Drawing Number		Originator		Rev
HE514503 -ACM		-EGN-		C01
A38_SW_PR_ZZ		-DR-LE-0092		
Location		Type Role Number

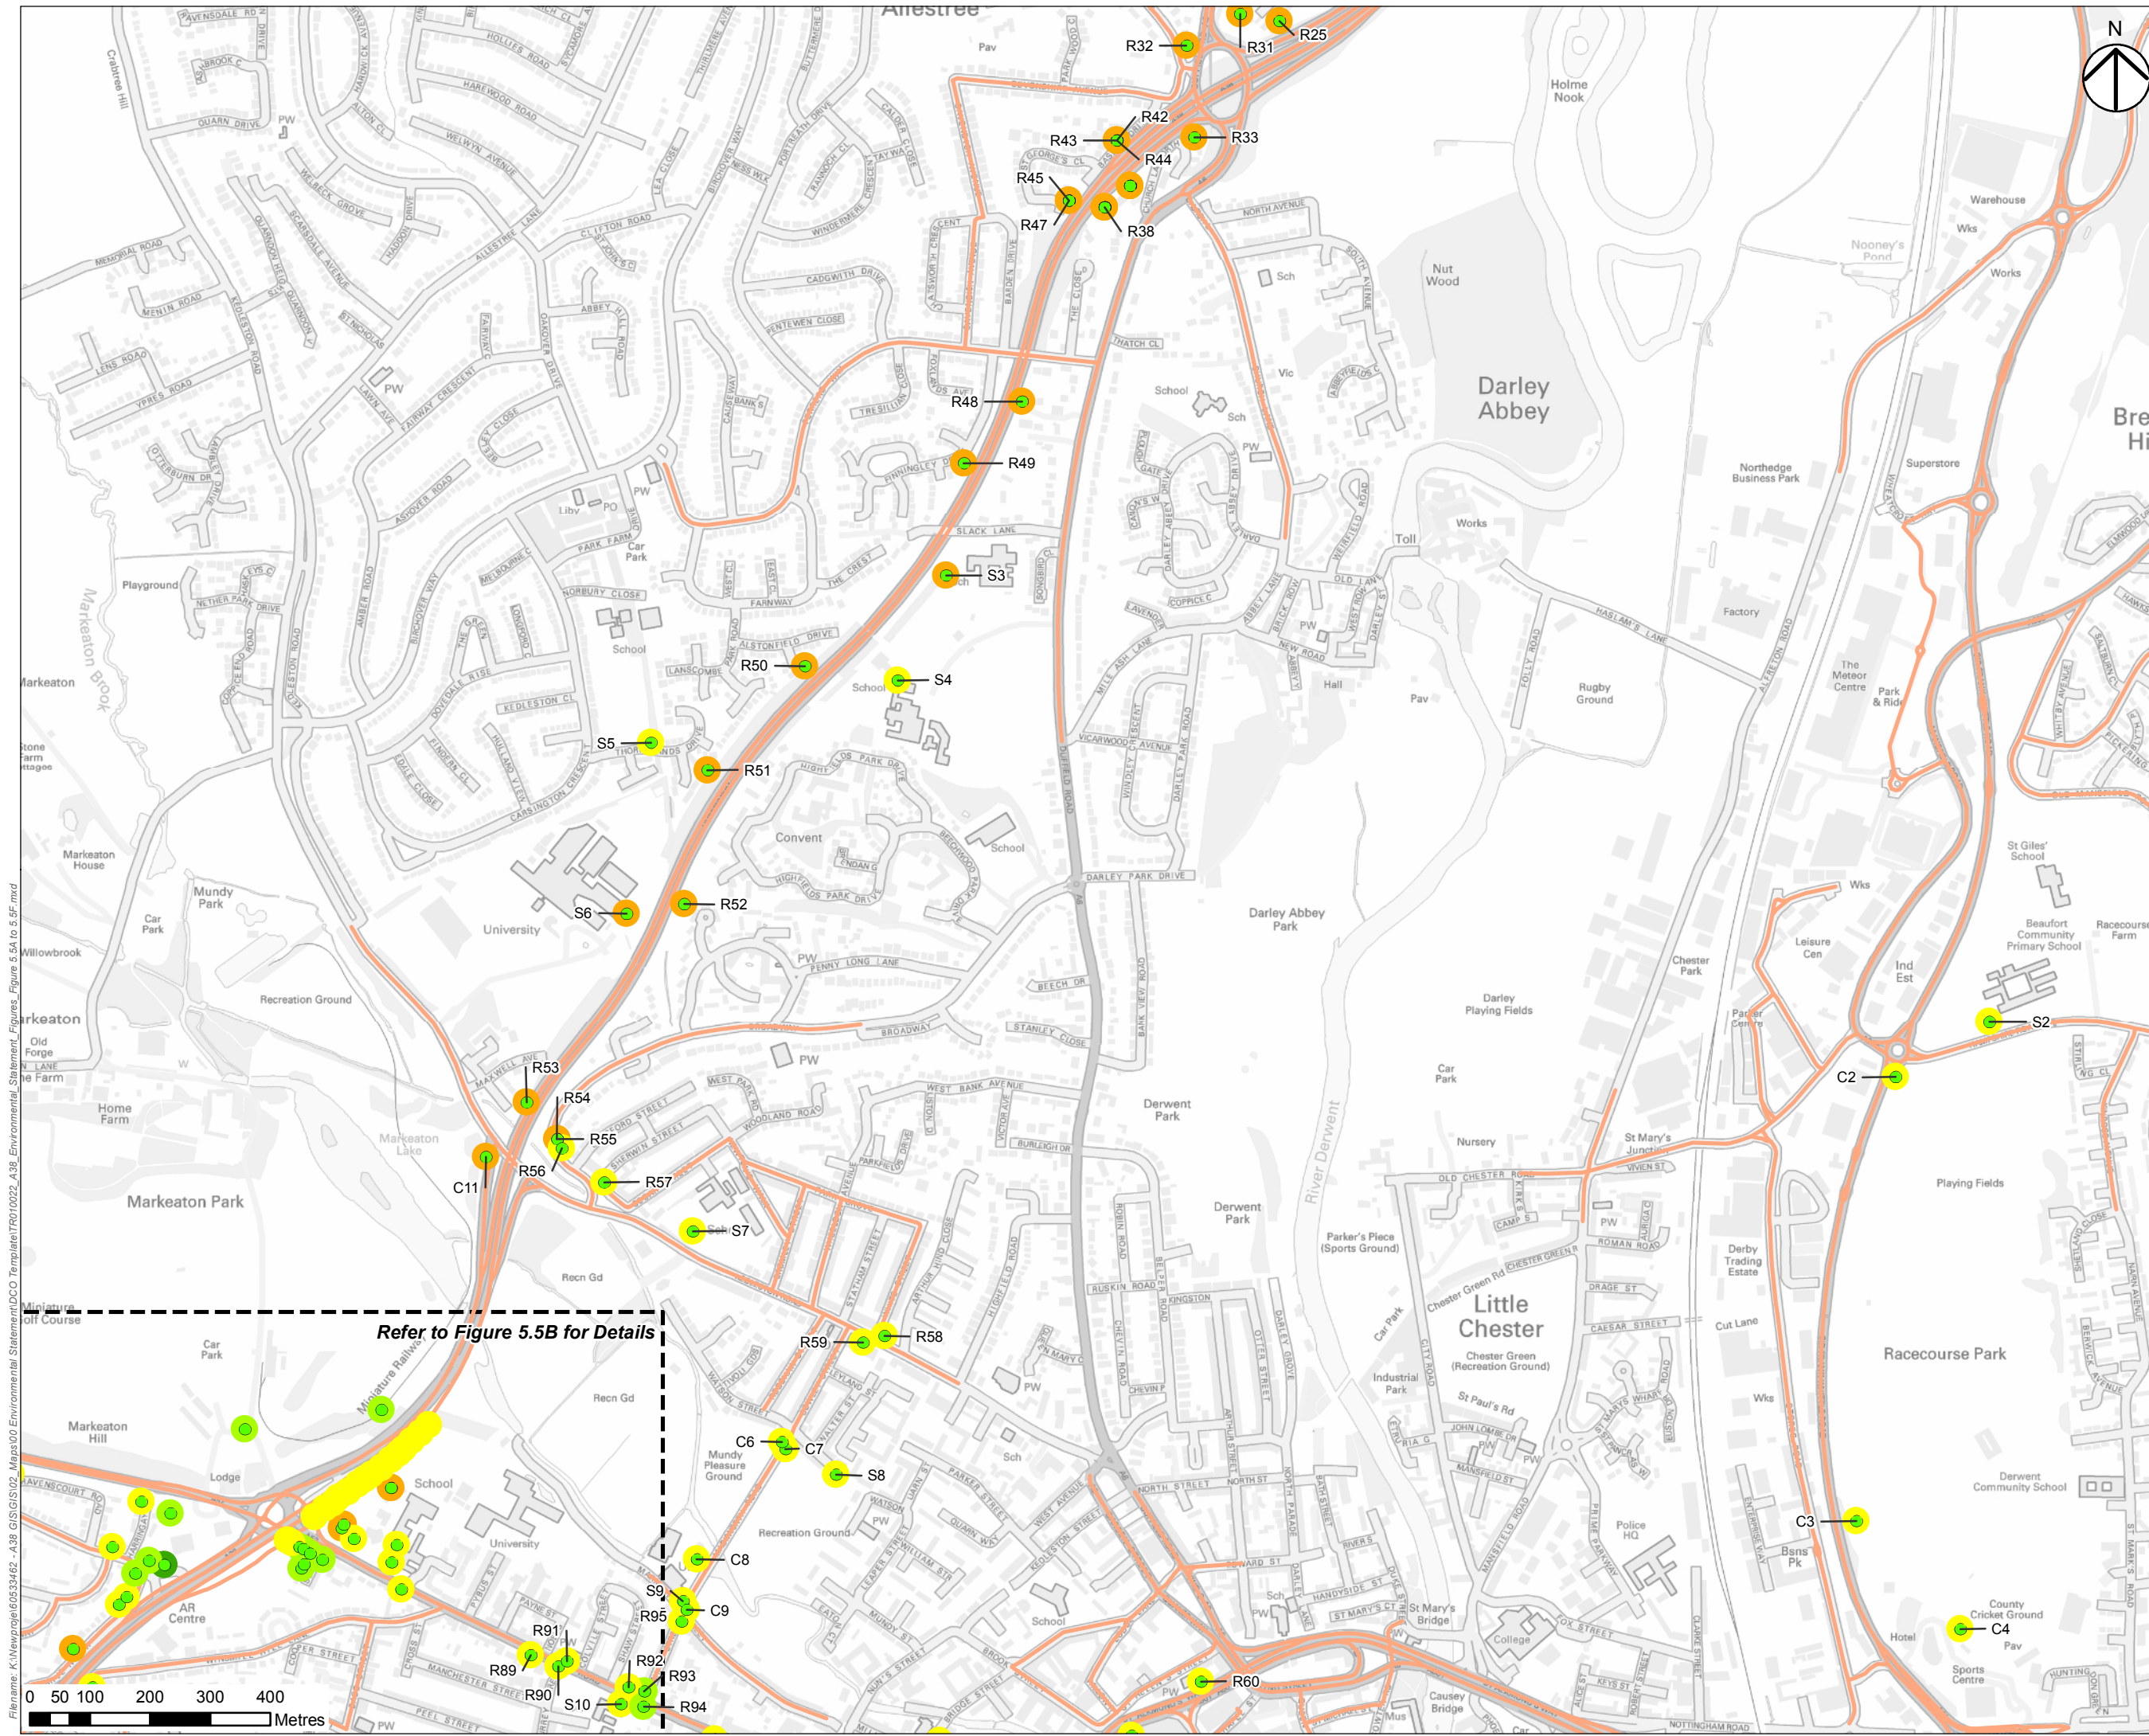
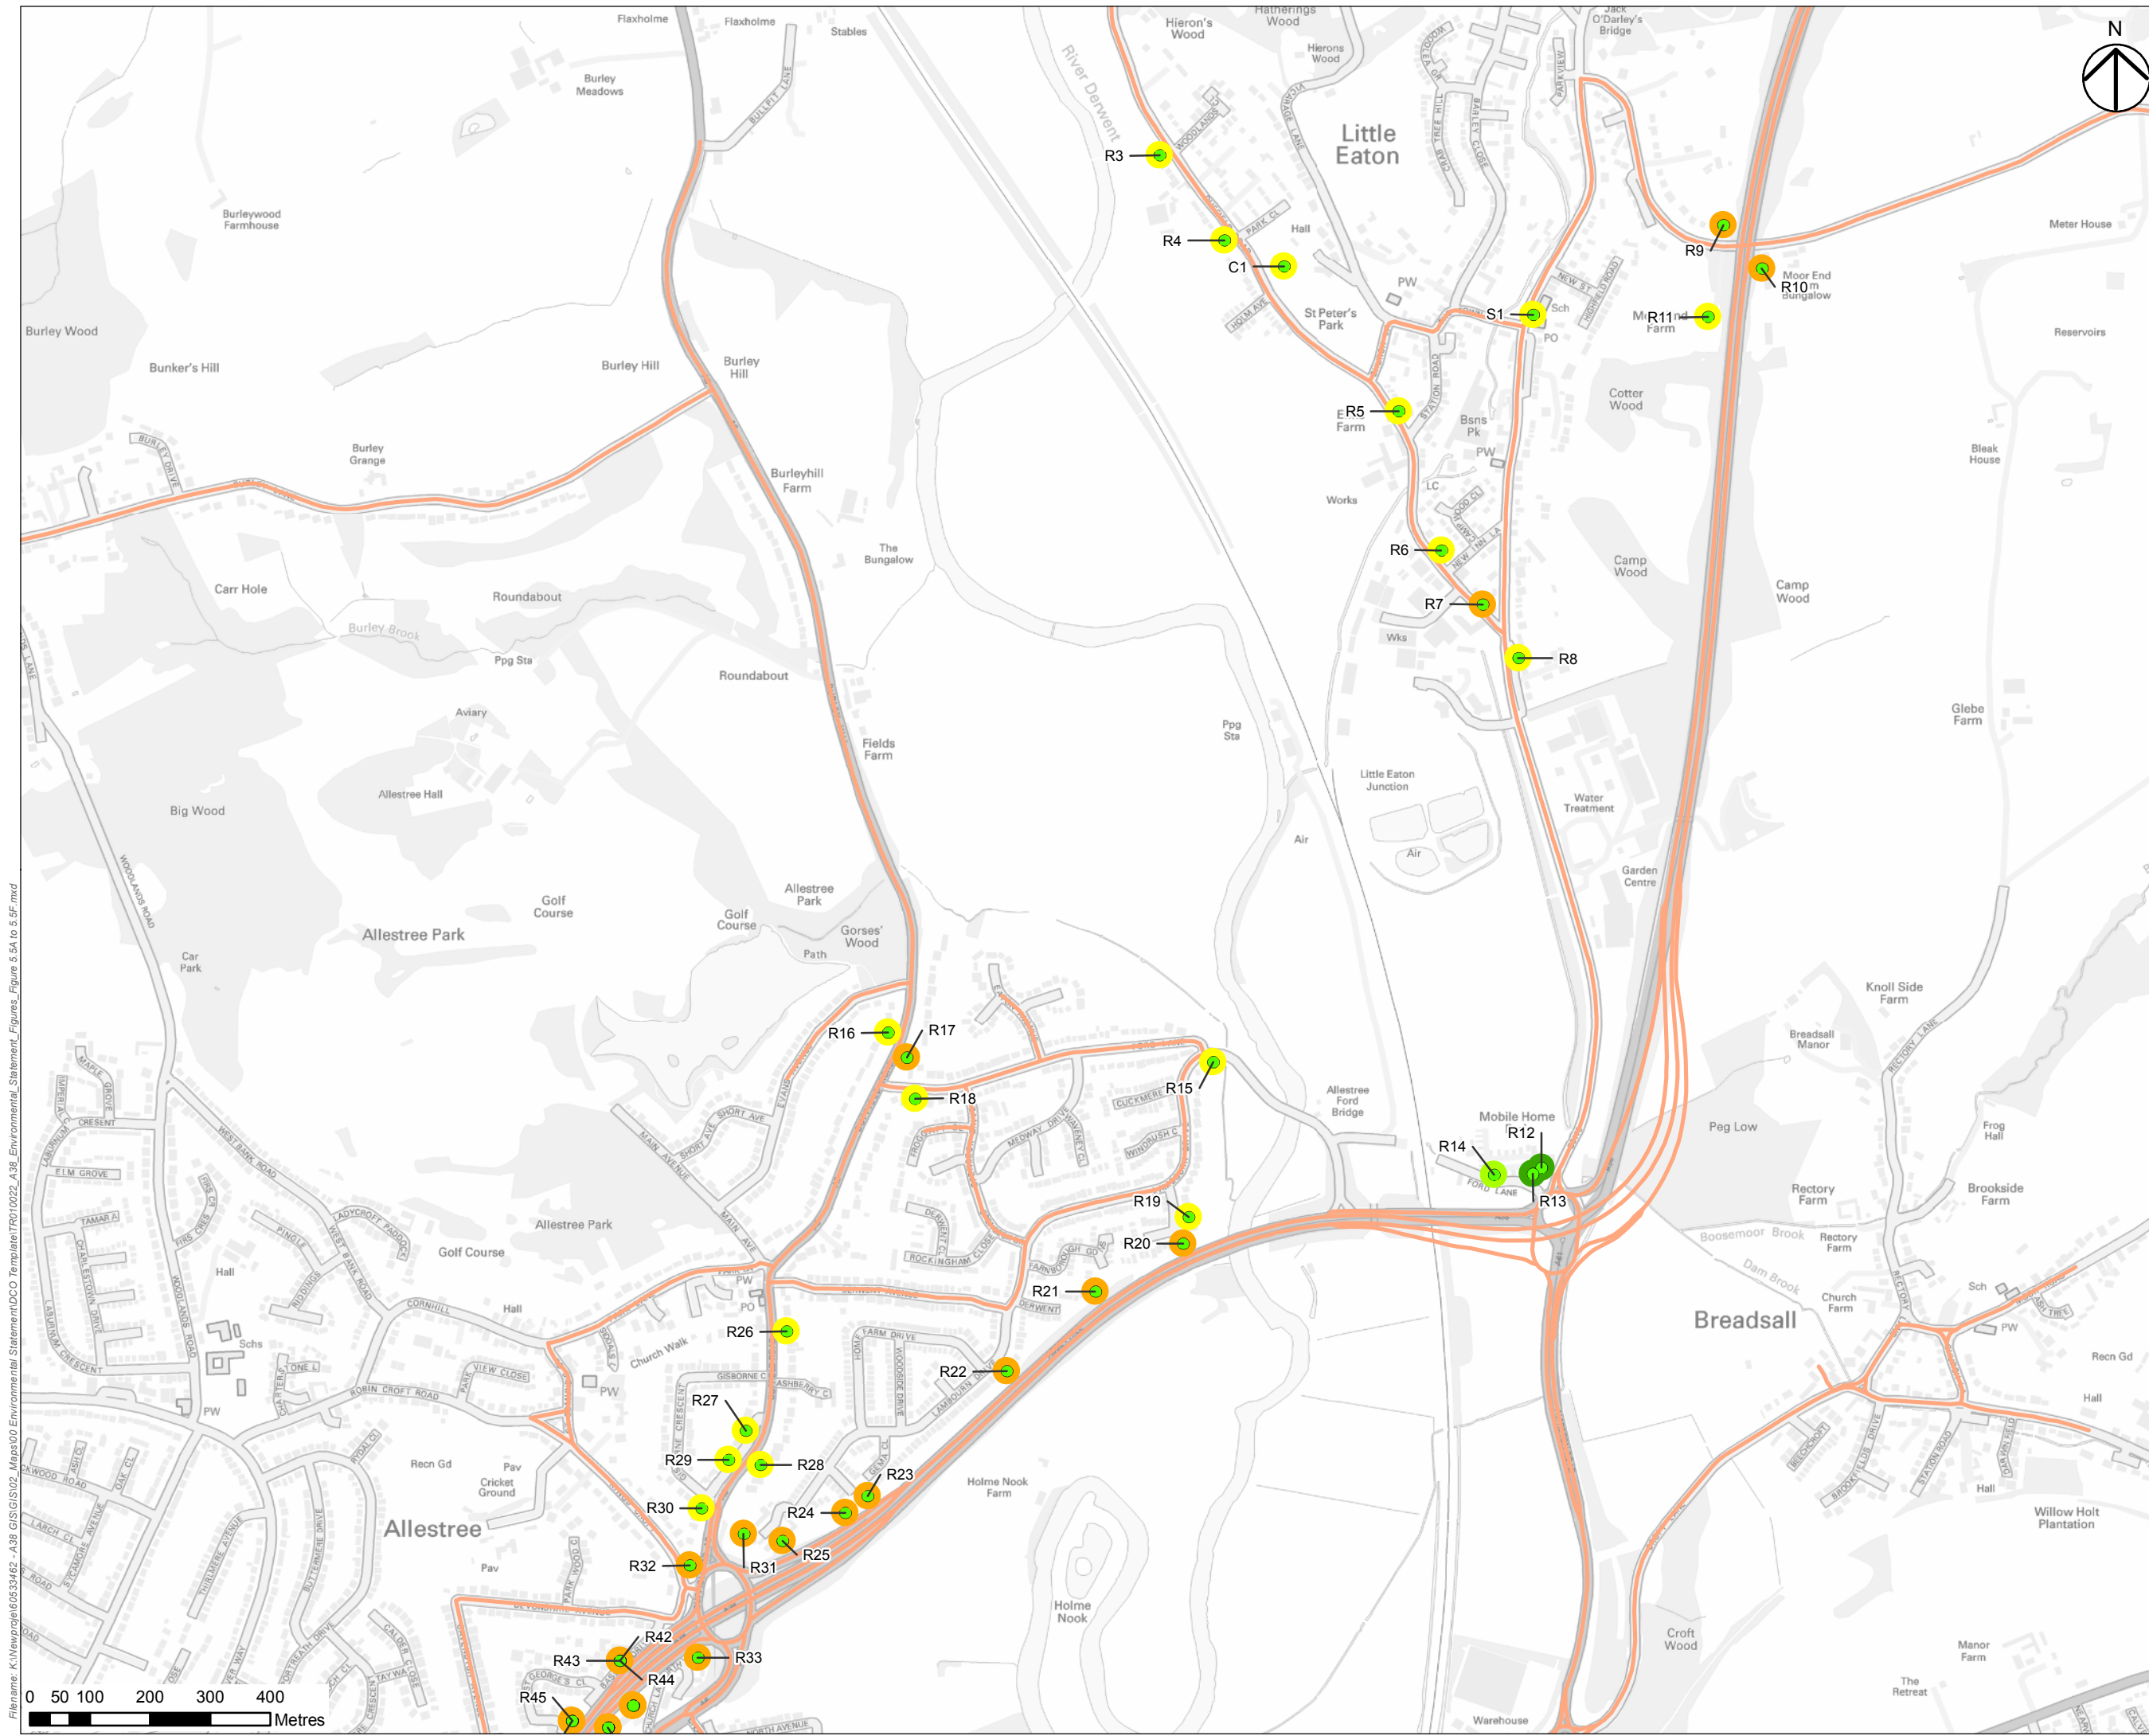
Q39 There are large disconnects between various HE claims. For example, in responses to Derby Friends of the Earth (REP6-035, Vol 18.84) the following statements are made, re Stafford St "With operation of the scheme, improvements in air quality are also expected in Stafford St" and "operation of the scheme is also expected to reduce traffic flows in Stafford St and this will be beneficial for air quality"

However, answering Q24 (REP6-025) "as detailed in ES para. 5.10.62 of ES Chapter 5: Air Quality [APP-043], reduced NOx and PM10 emissions are expected in 2024 both with and **without** the Scheme as compared with the baseline (2015)." HE 8.86 Supplement to Air Quality Assessment Risk, Table 1 clearly shows NO2 limit value exceedances (see also National Friends of the Earth evidence, pg 4, Derby Friends of the Earth HE Response, 3 A38)

Q42 In response to FOE (REP6 035, Vol 18.84) re Stafford St "NO2 concentrations will be within the limit value both with and **WITHOUT** the scheme" Therefore, there is no clear benefit of the scheme
